**WEST SUSSEX COUNTY COUNCIL
STRATEGIC PLANNING CONSULTATION**

DATE: 7th June 2013

SUBJECT: LU/116/13 - Demolition of existing commercial properties and erection of 66 residential dwellings, incorporating 20 affordable dwellings, parking provision, access and landscaping - This application is a Departure from the Development Plan.

LOCATION: Hollyacre, Toddington Lane, Littlehampton, West Sussex, BN17 7PP

Drawing Title
**Plots 27-30
Plans**

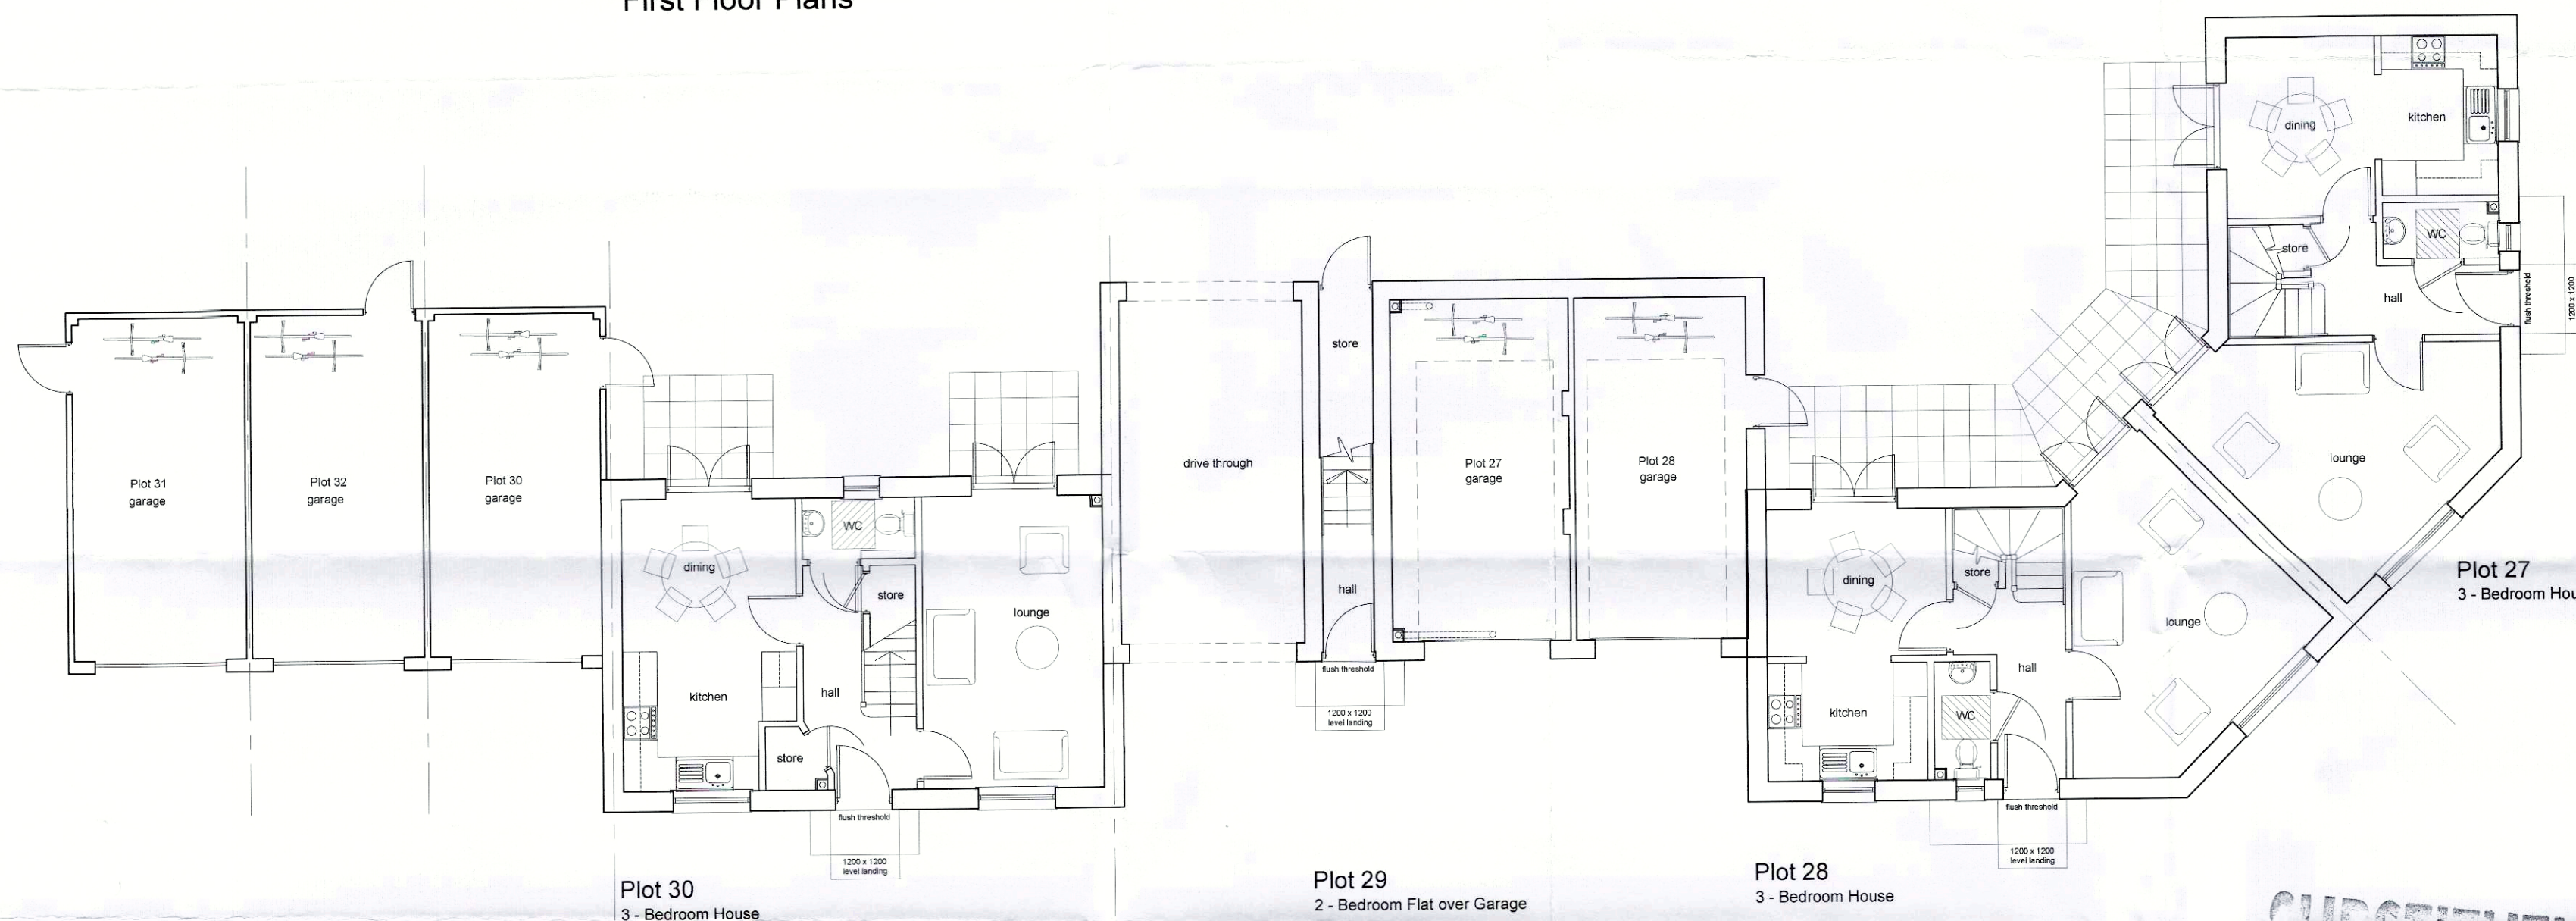
Also, the access leading to the parking court between plots 28 and 29 should be widened to at least 3.5m. The road width between parking spaces for plots 27-30 and 47-50 should be widened to 6m.

Also, further visitor parking should be provided in the vicinity of the following plots:

1. 26-30 and 46-50
2. 57-61
